Application No: LU/75/20/HH
Site Address: 10 Gladonian Road Littlehampton BN17 6JW
Description of works: Single storey rear extension.

Thank you for your internet representation made on 29th May 2020 which has been recorded as an objection with the comments as follows:

sheet 1 of 3

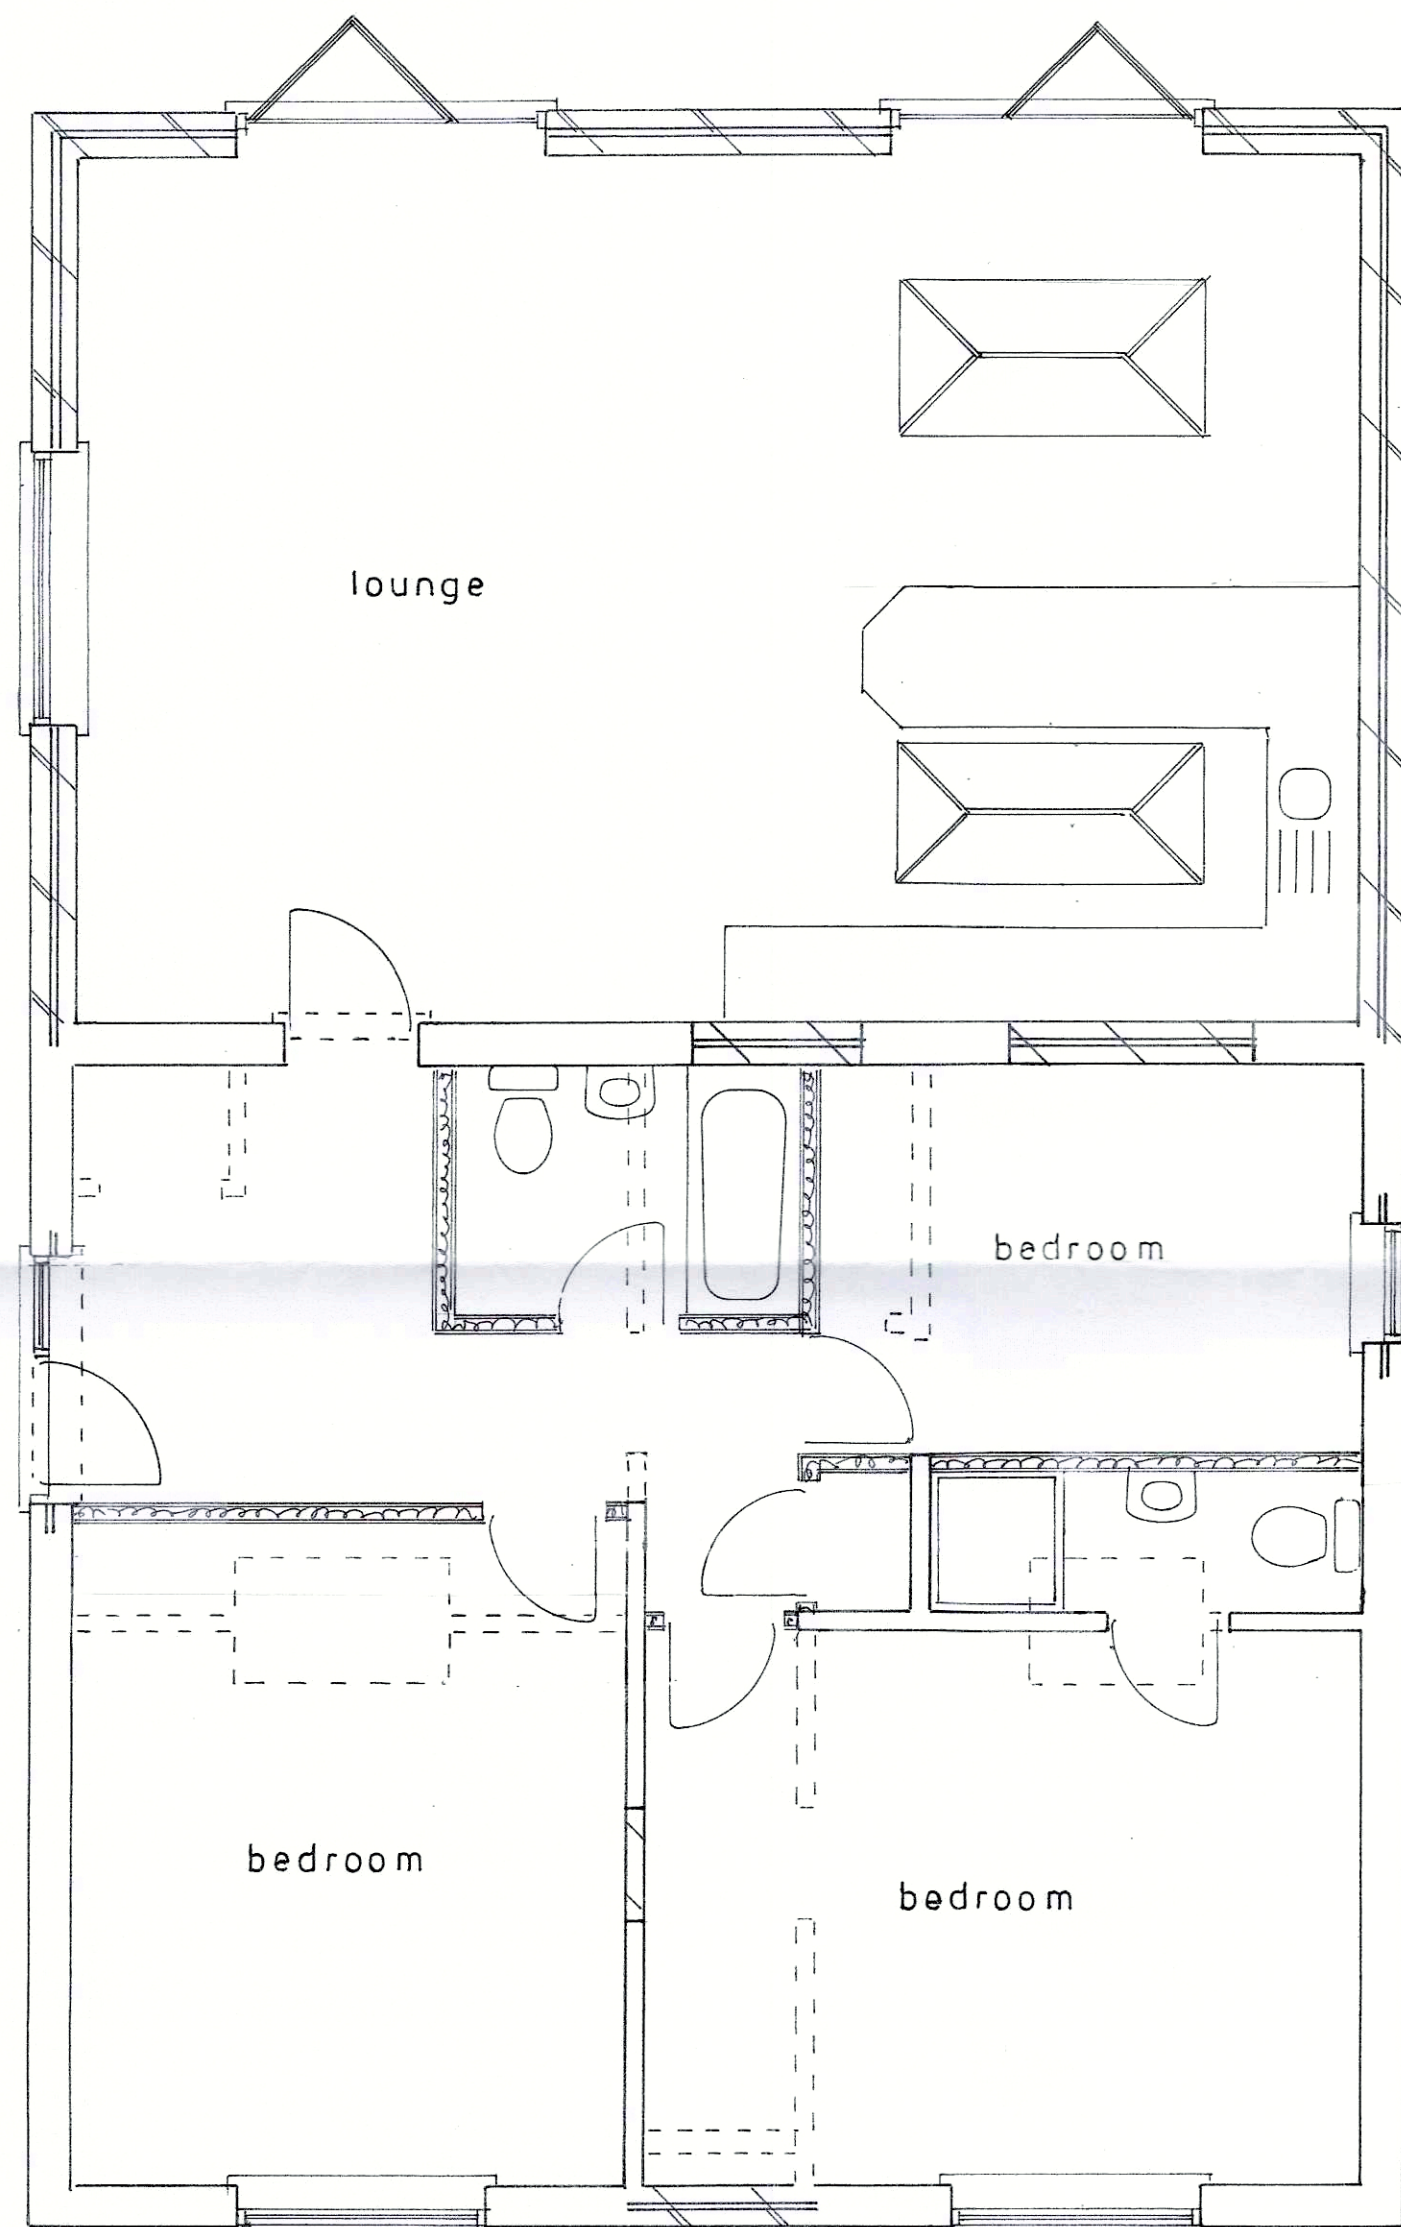
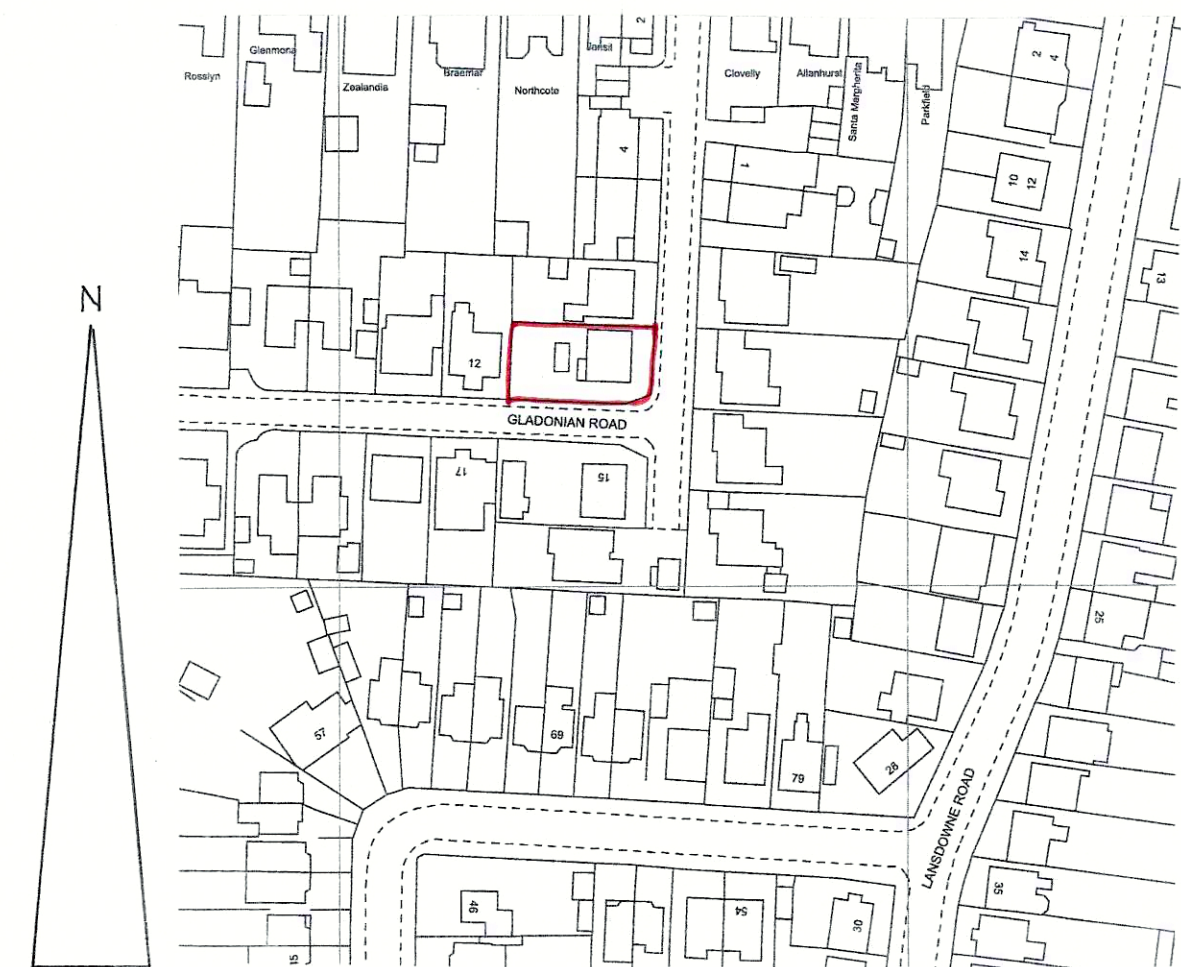
(a) The north chimney has not been removed.

This must have an impact on the proposed interior layout as shown on the plans.

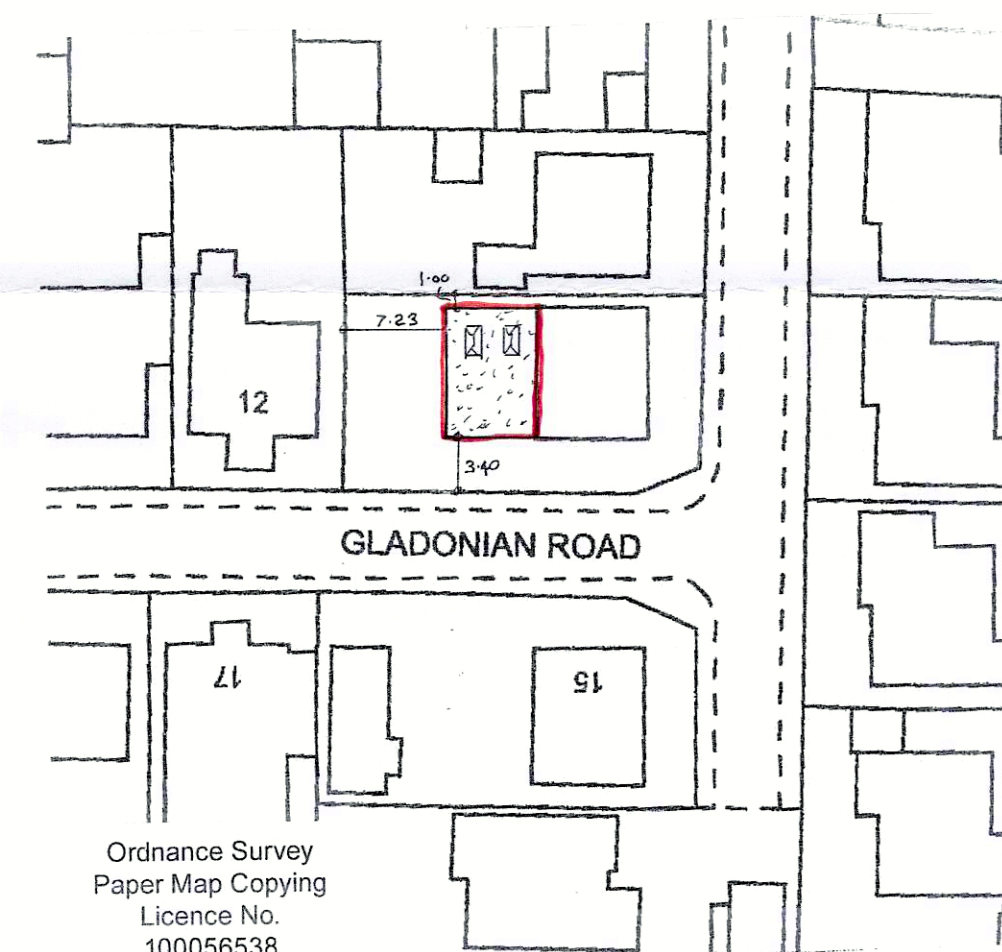
1. A soakaway has been installed 3.9 metres from our property wall, 2.0 metres from the boundary and 0.5 metres from the adjacent highway.

This is in breach of the Building Regulations 2010 - Drainage and Waste Disposal Approved Document H - Drainage and Waste Disposal (2015 Edition) which states:

3.25 Infiltration drainage is not always possible.

Infiltration devices should not be built:

a. within 5 metres of a building or road or in areas of unstable land.

I must insist that this soakaway be moved so that it is compliant with regulations, tested accordingly and the results be made available to affected parties.

(b) A large hardstanding area has been laid to the

south side of the property. This places more load onto the surface water drainage.
